**M1 Pacific Motorway extension to Raymond Terrace (SSI 7319)
Advice on the Environmental Impact Statement (EIS)**

Thank you for the request for advice from Public Authority Consultation (PAE-24749572), requesting the review by the NSW Environment Protection Authority (EPA) of the Environmental Impact Statement (EIS) for the proposed M1 Pacific Motorway extension to Raymond Terrace (Application SSI-7319).

ATTACHMENT A: EPA COMMENT ON EIS FOR M1 PACIFIC MOTORWAY EXTENSION TO RAYMOND TERRACE (SSI 7319)

Location: L09 - 2213 Pacific Highway, Heatherbrae

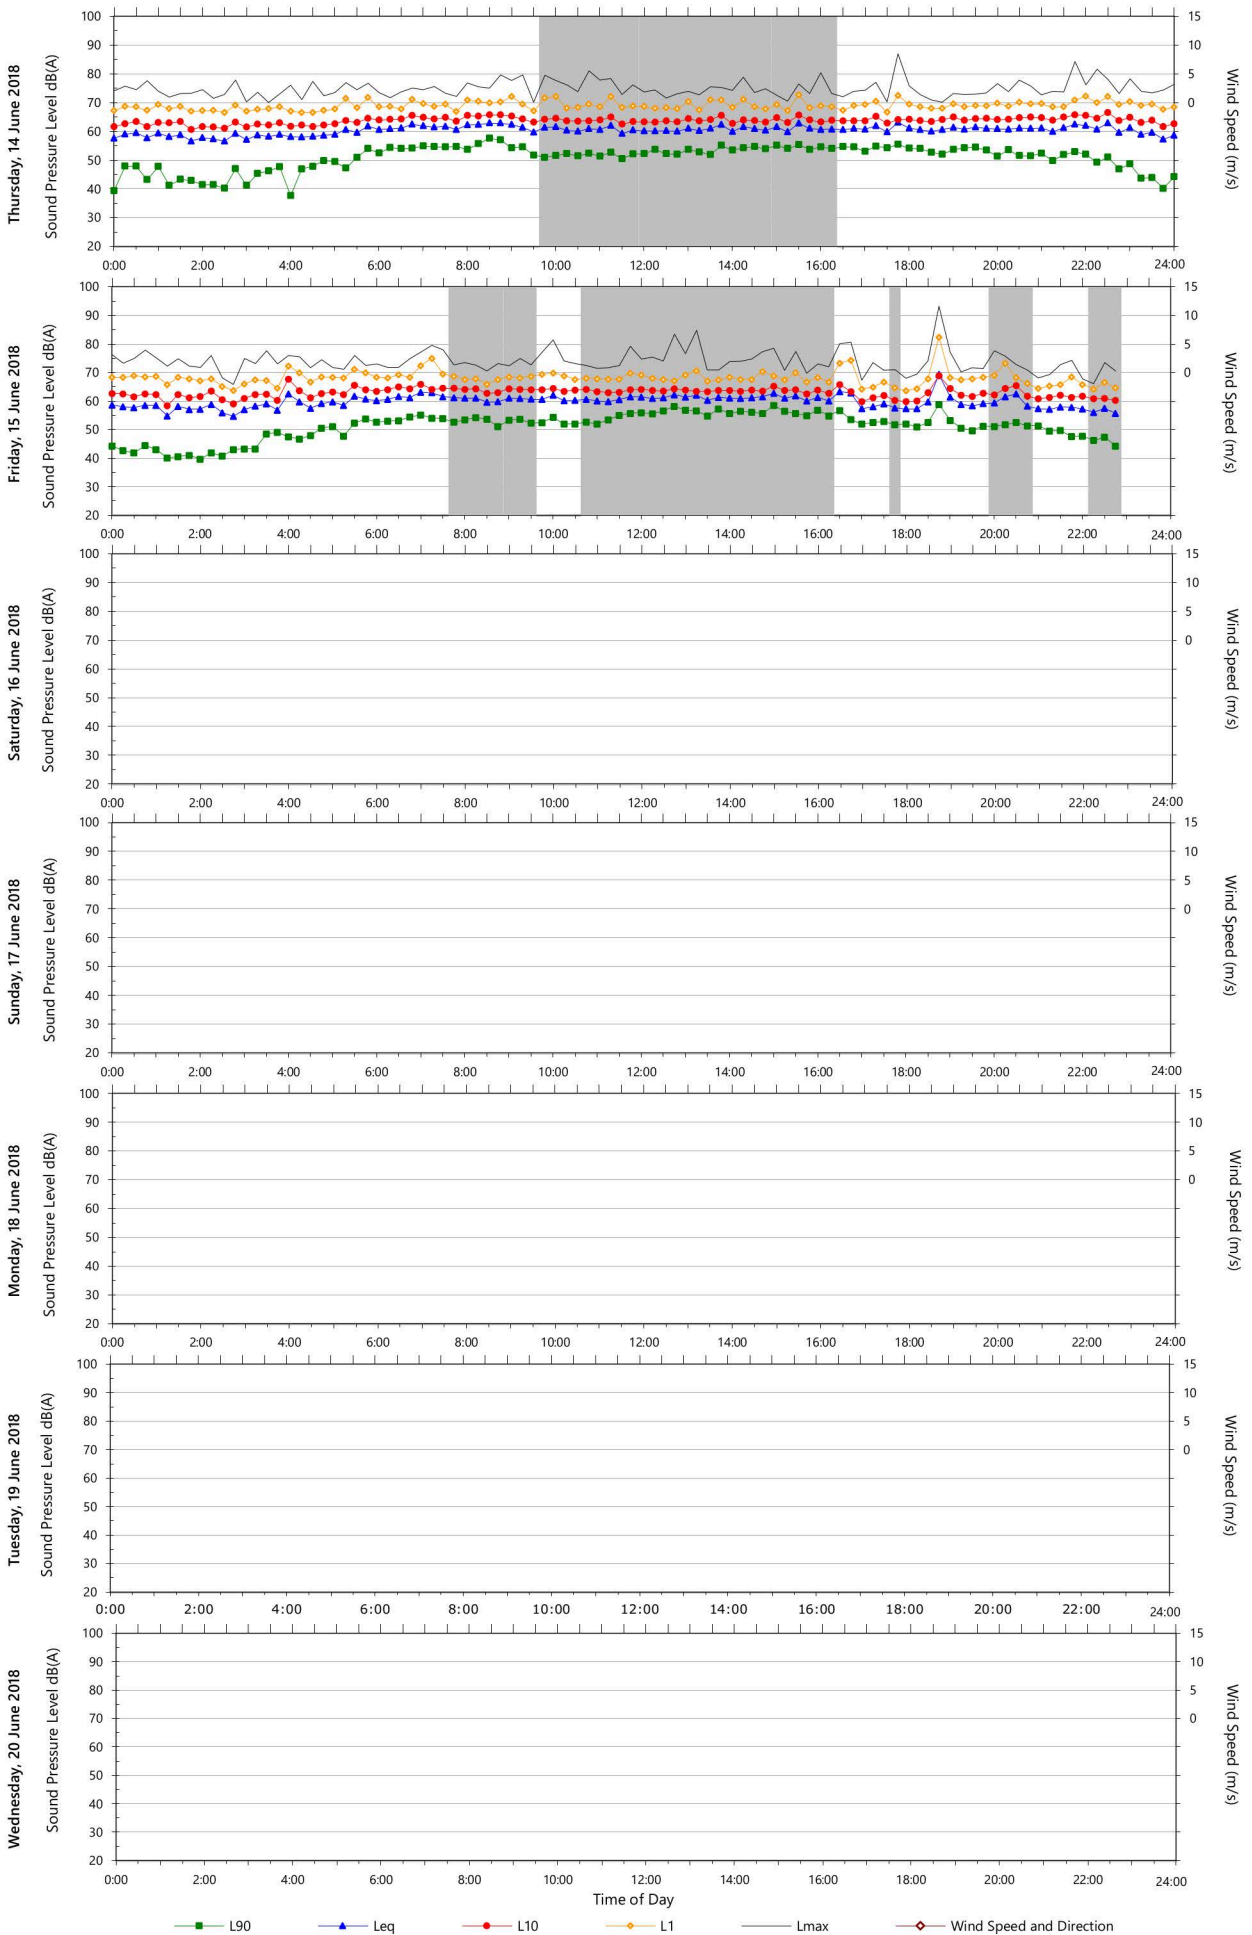
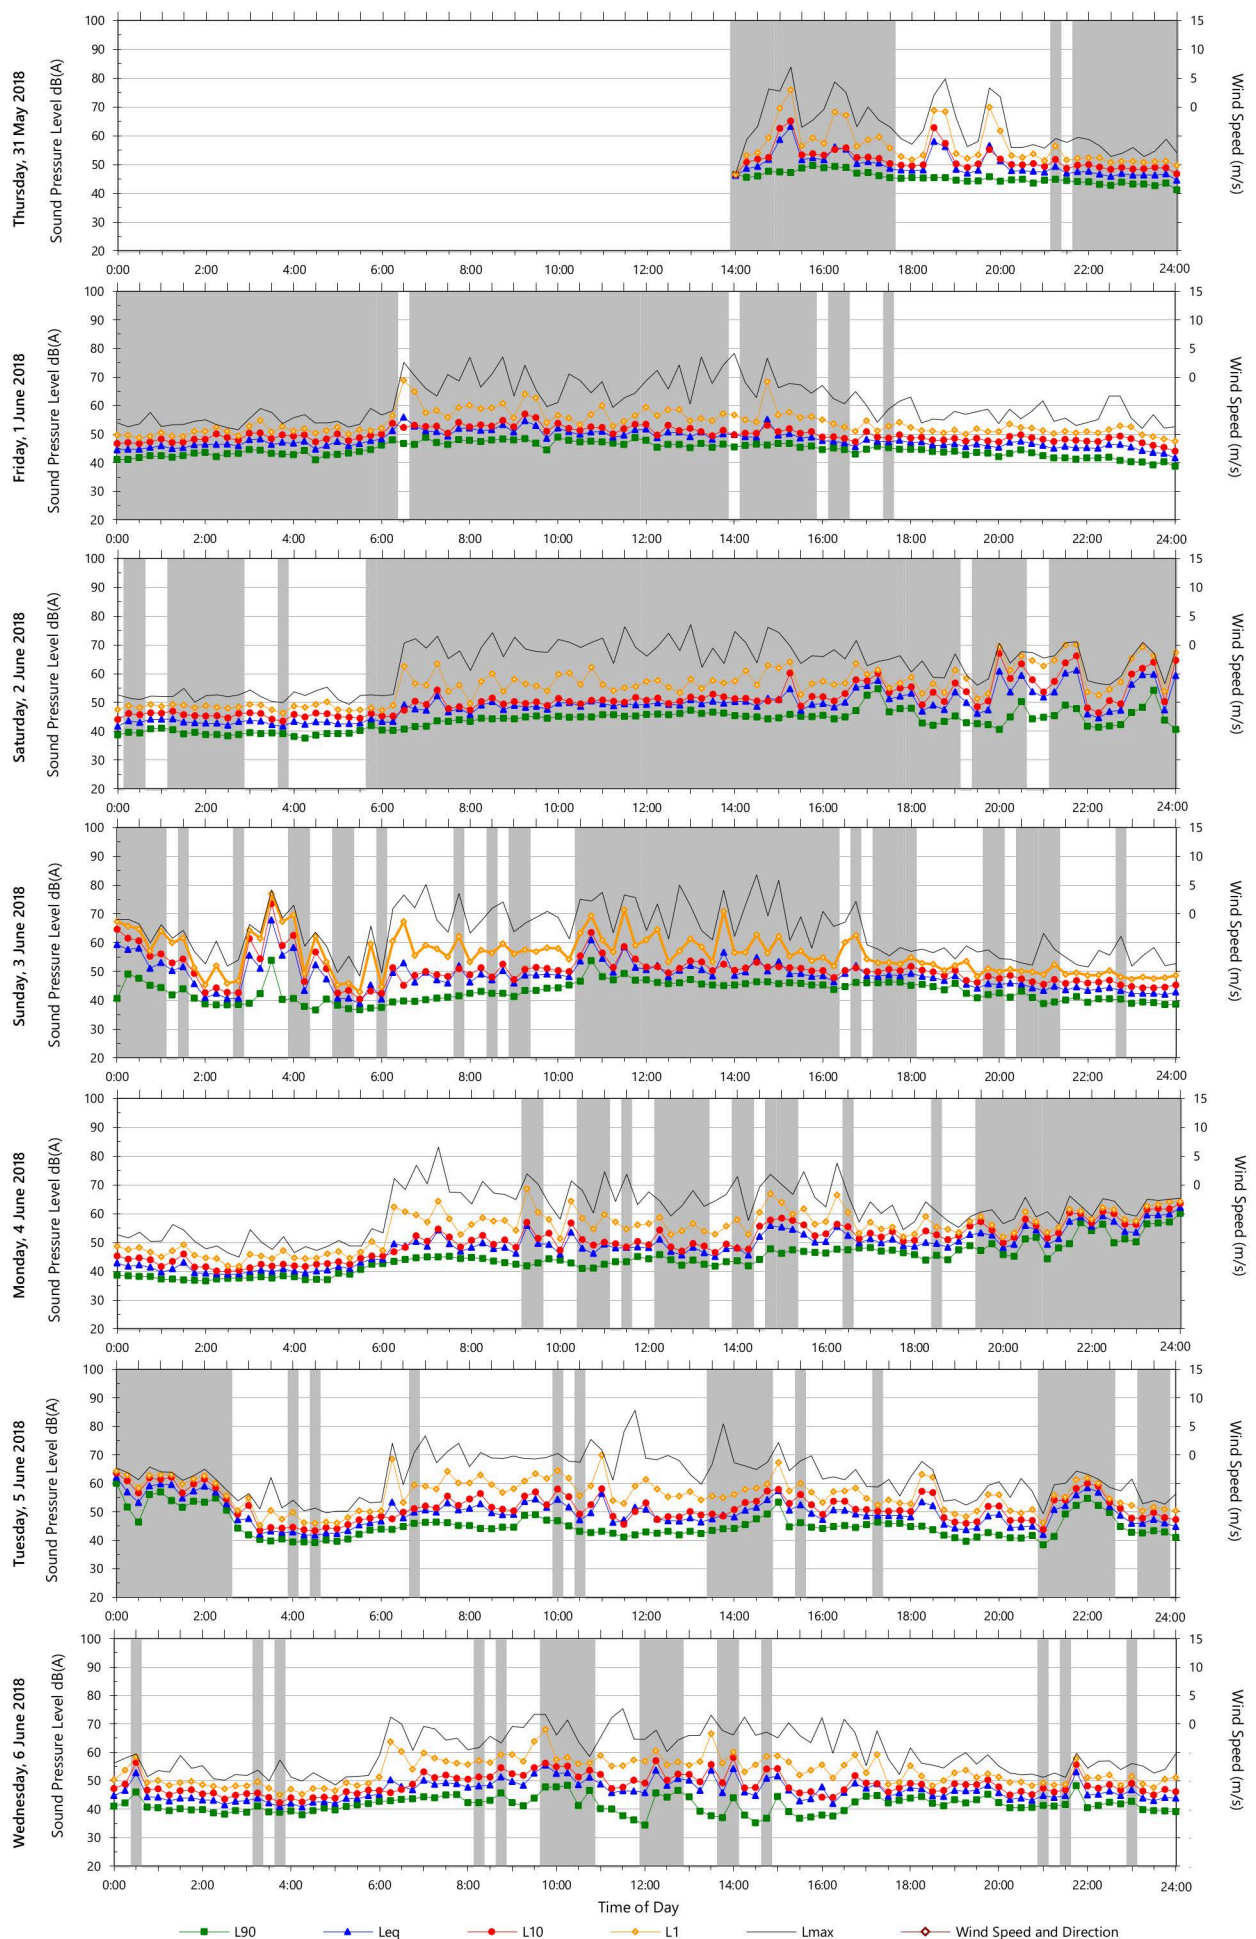
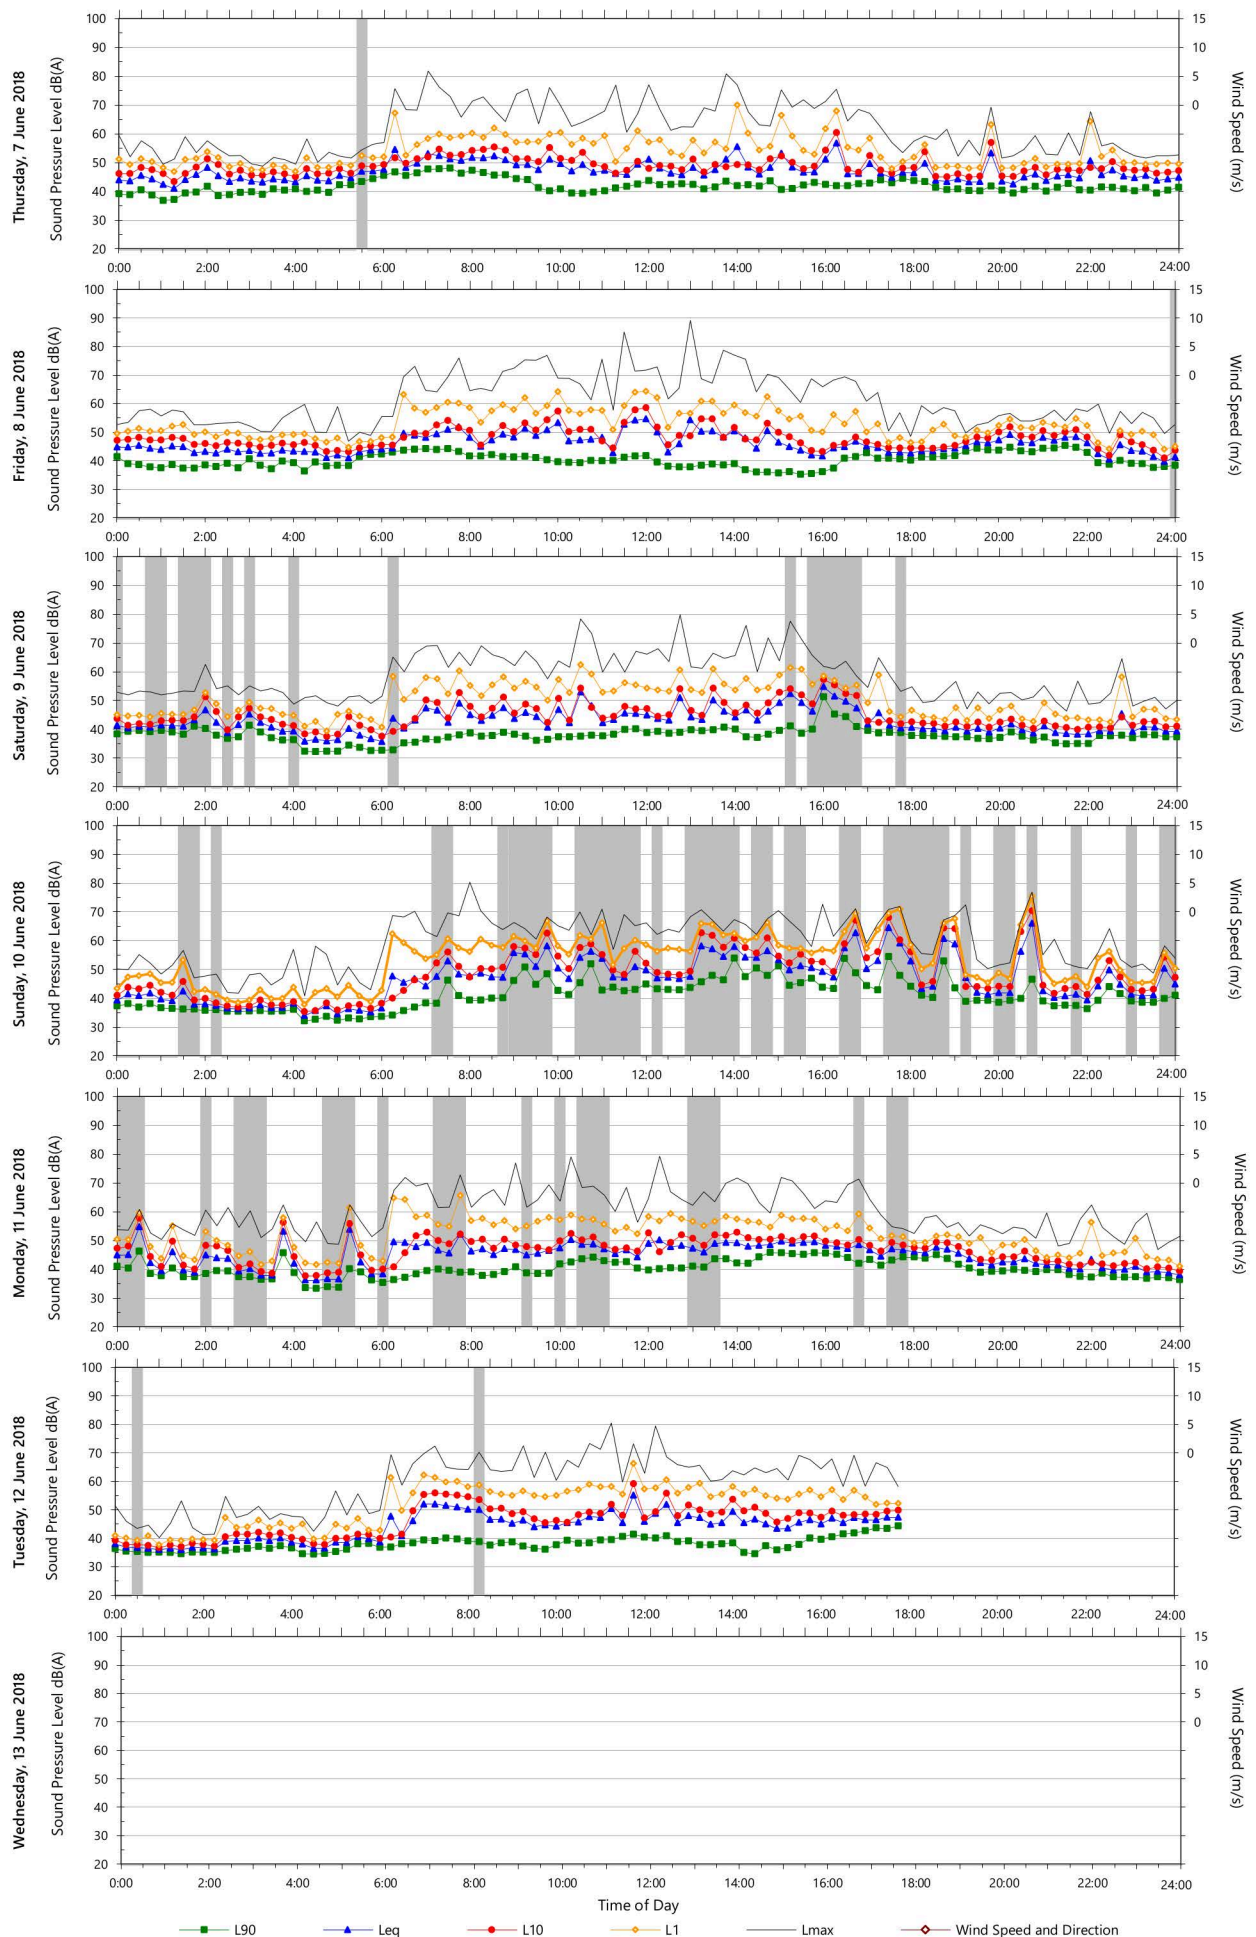
A review of the noise monitoring graphs in NIA Appendix B.2 indicates that further justification for the adequacy of noise monitoring presented or additional information is required.

A significant amount of data appears to have been excluded due to either inclement weather or extraneous noise. The EPA is concerned that the extent of data excluded means that it may not be representative of long term background noise levels, and therefore its suitability to be used to establish reliable noise management levels could be called into question.

Locations L01 to L014 (inclusive) appear to have no more than 5 and in some cases less than 3 valid periods out of the total monitoring duration. Locations L15 to L20 appear to be less affected, however there it is still not clear if sufficient valid data has been presented.

Fact Sheets A and B in the Noise Policy for Industry (NPfI) set out the EPA's requirements for establishing background noise levels. Due to the amount of data excluded, it is currently not clear if these requirements have been satisfied nor if sufficient valid data has been presented in order to establish representative background noise levels.

Noise monitoring was also conducted in 2016 for the purposes of measuring road traffic noise. Due to the amount of data excluded at Locations L13 to L20, further justification is needed that the remaining data, after invalid samples were excluded, provides sufficient amount of data to enable a representative calculation of the traffic noise descriptors.

The proponent reviews the noise monitoring data in the NIA in the context of the monitoring requirements set out in the NPfI and for each location and either:

- Provide a justification and demonstrate that the requirements of the NPfl have been fulfilled; or
- Provide additional data that fulfills the monitoring requirements in the NPfl.

The EPA also recommends that the proponent either:

- Provides justification and demonstrate that the data presented for road traffic noise descriptors is sufficient to be representative; or
- Provides additional valid data.
